This is to certify that East Danforth Llc /Nathan H ikes
has permission to build 14' dormer on 3rd floor a three story rent building
AT 63 R Danforth St City of Portland, Oregon 97204 040 A024001

City of Portland, Maine - Building or Use Permit Application

Permit No: 05-1006	Issue Date: NOV 3 2005	CDL: 040 AC24001
-----------------------	---------------------------	---------------------

RE: 63 Rear Danforth Street – 040-A-024 – R-6 Zone. – application #05-1006

63 rear 3<sup>rd</sup> Floor

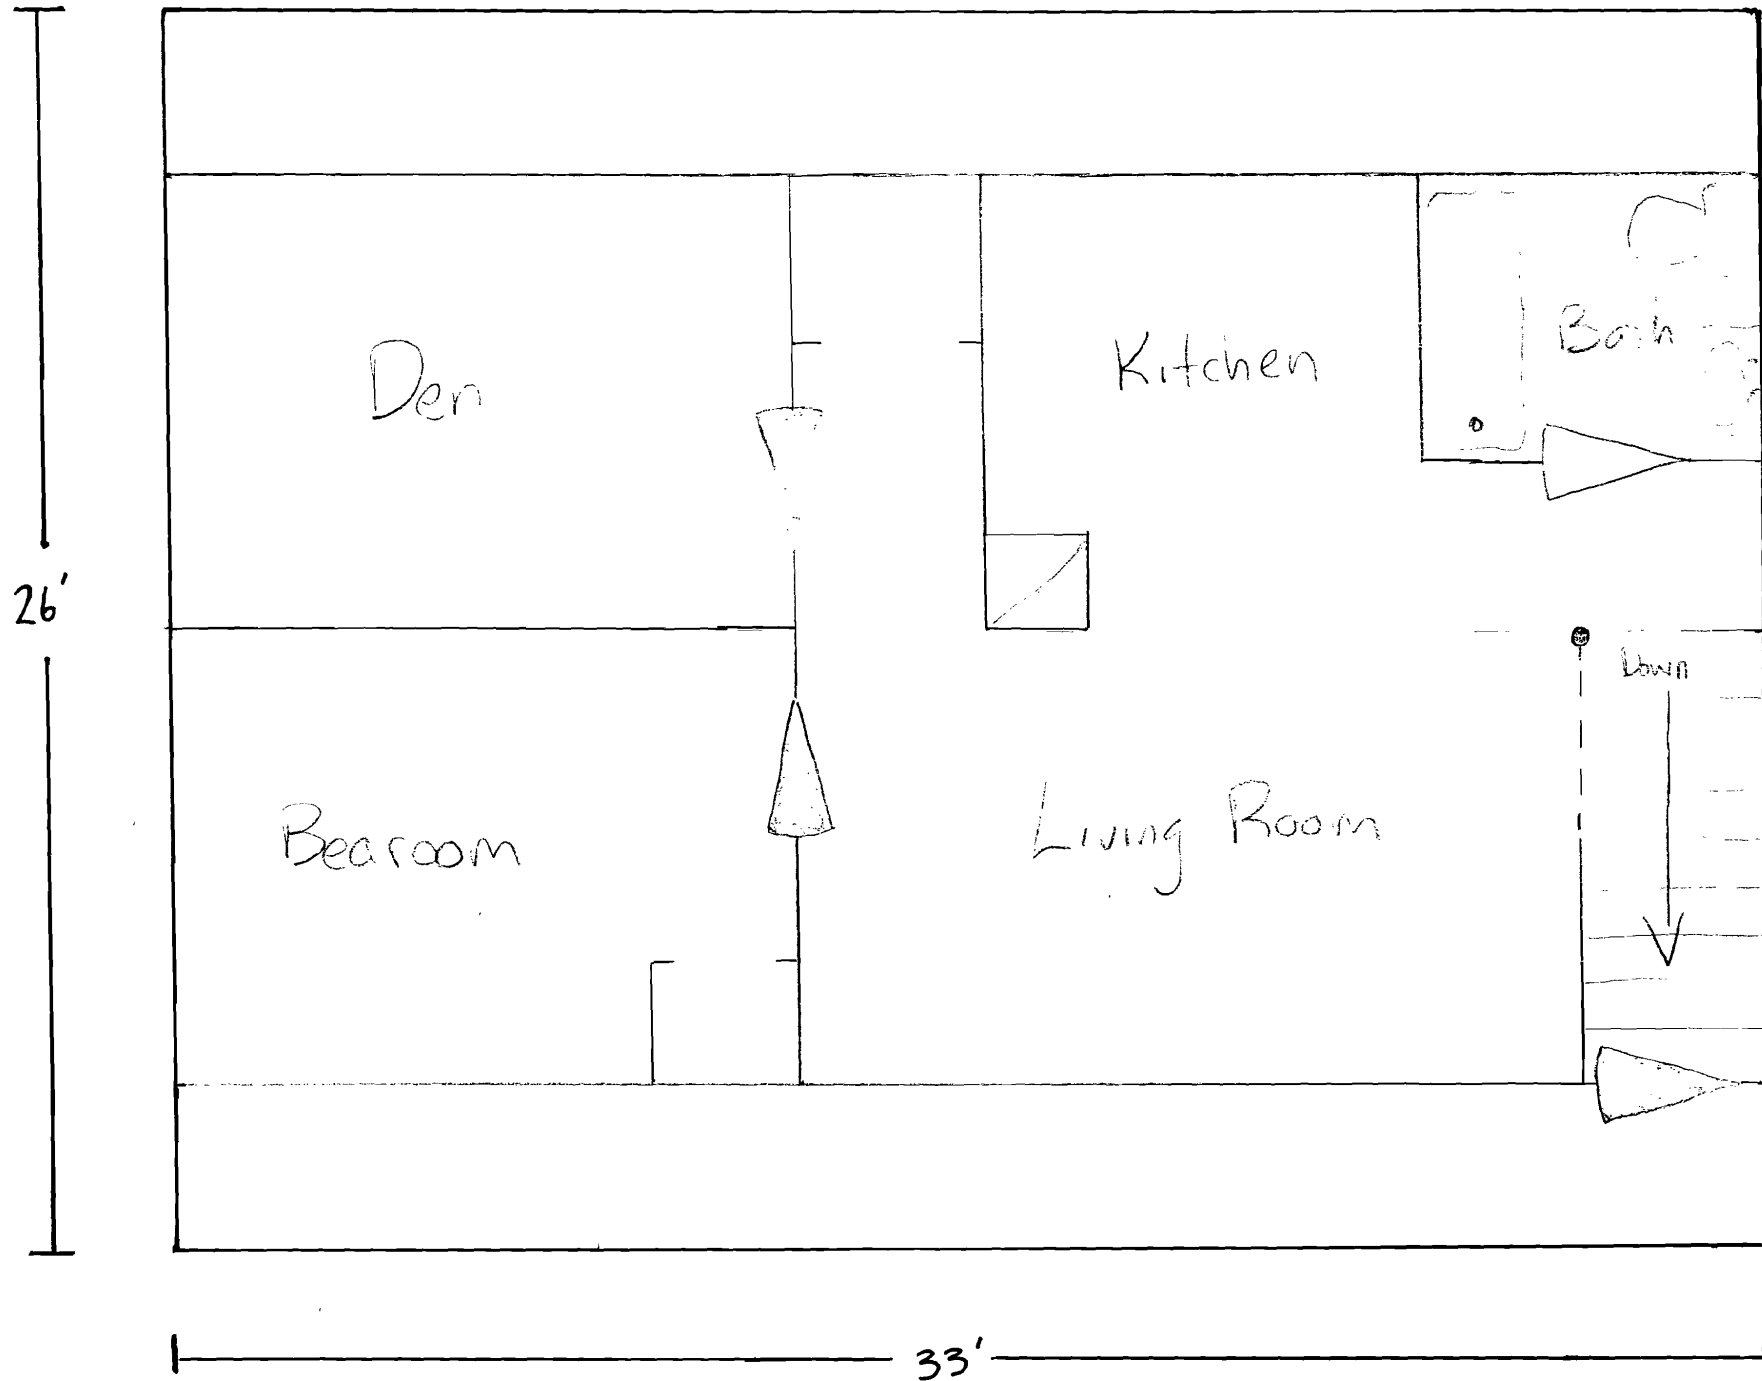
- 1) The allowance for this expansion is based upon section 14-436 which states that if the property is legally nonconforming as to lot size and setbacks, you are allowed to expand upward not more than 50% of the first floor footprint. Your current request for a dormer uses 27% of the allowable 50%. The 50% expansion is allowed only once during the life time of the building.

11/02/2005-jmb: Spoke w/Nathan H. About existing use & egress; kitchen/bath in a sloped ceiling. Will change rafters to 2x10, insulation per code. No tub/shower on window wall. Ok to issue
